From: Nicola Spencer on behalf of Planning.Responses
Sent: 28 February 2018 12:43
To: Julie Grieves
Subject: FW: Y/52/17/DOC - Longacre, Maypole Lane
Attachments: 17-1779 Sustainable Drainage Management Plan Rev A.pdf; 1937-14-TST-01-LAVENDER COTTAGE - Typical Silt Trap_Catchpit.pdf; 17-1779 Stormwater Drainage Rev A Sept 2017.pdf; 1937.14 Groundwater monitoring log 2017.pdf; 17-1779 Soakaway and Driveway.pdf; 17-1779 Rear Drainage Report Rev B.pdf; 17-1779 Front Drainage Rev A.pdf; 17-1779-01-A.pdf

1. Please provide a clean copy of the stormwater drainage design document dated Sept 17, as the scanned copy is unreadable in places.
2. Provide details of the groundwater level observations in Feb 2017.
3. Calculations need to include an allowance for climate change ie. 30%.
4. Page 2 of the Sustainable Drainage Management Plan appears to be missing.

Lavender Cottage Drainage Plan

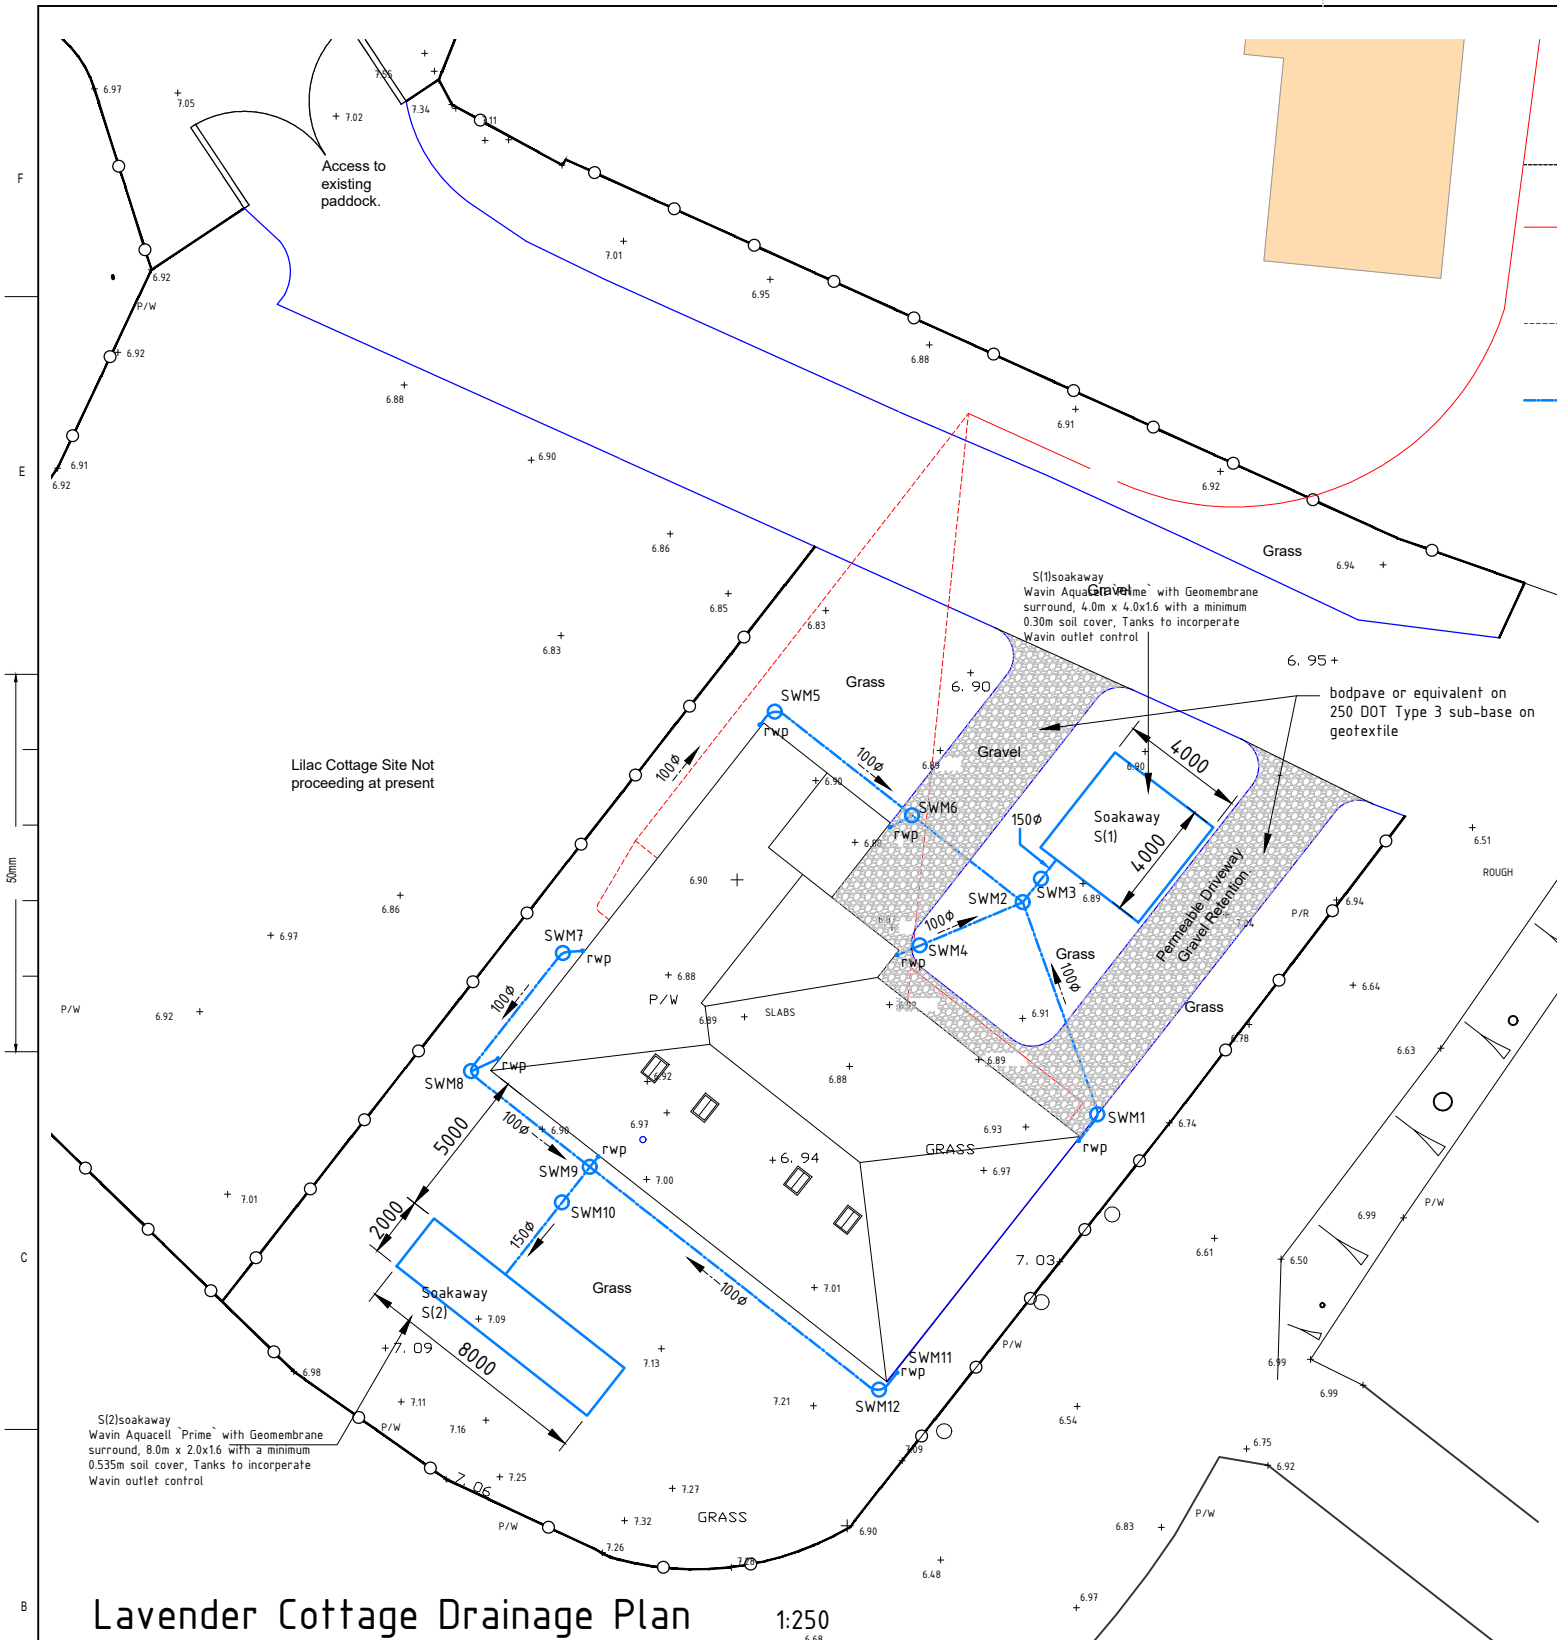
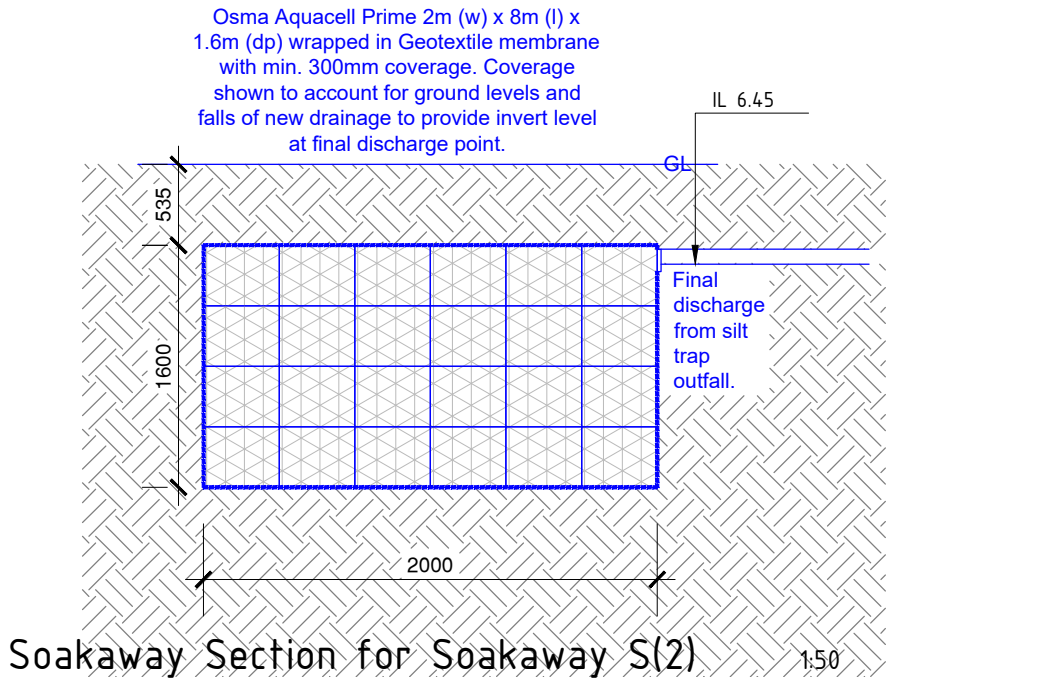
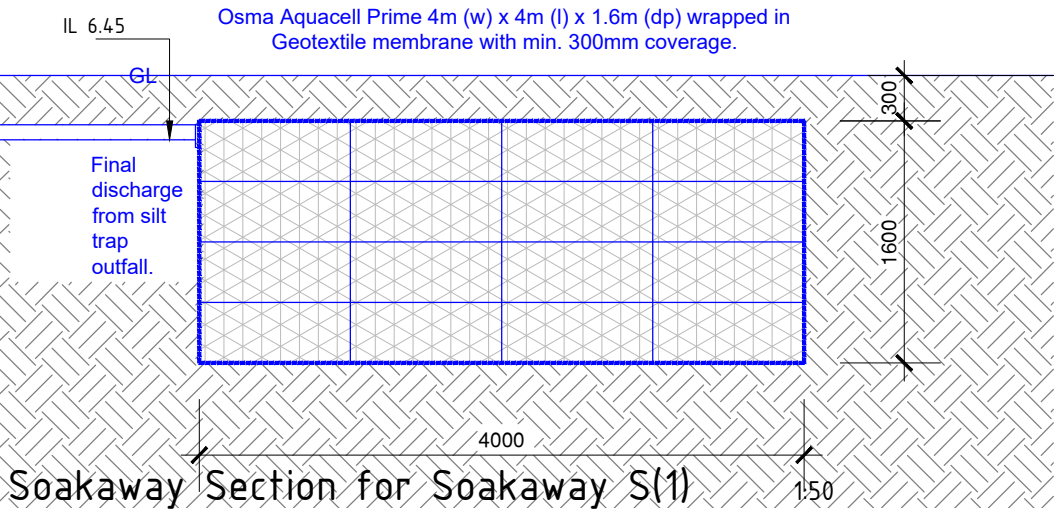
5. Provide catchpit construction details.
6. Provide additional manhole on south west corner of building.
7. I note the driveways are to be gravel surfaced, however, they need to be designed to store the 1 in 100 year storm+30% within the sub base. Please provide construction details and calculations in this respect.

6. Provide additional manhole on south west corner of building. Refer to attached drawing 17-1779-01A.
7. I note the driveways are to be gravel surfaced, however, they need to be designed to store the 1 in 100 year storm+30% within the sub base. Please provide construction details and calculations in this respect. Refer to attached drawing 17-1779-01A and 'Soakaway and Driveway' document.
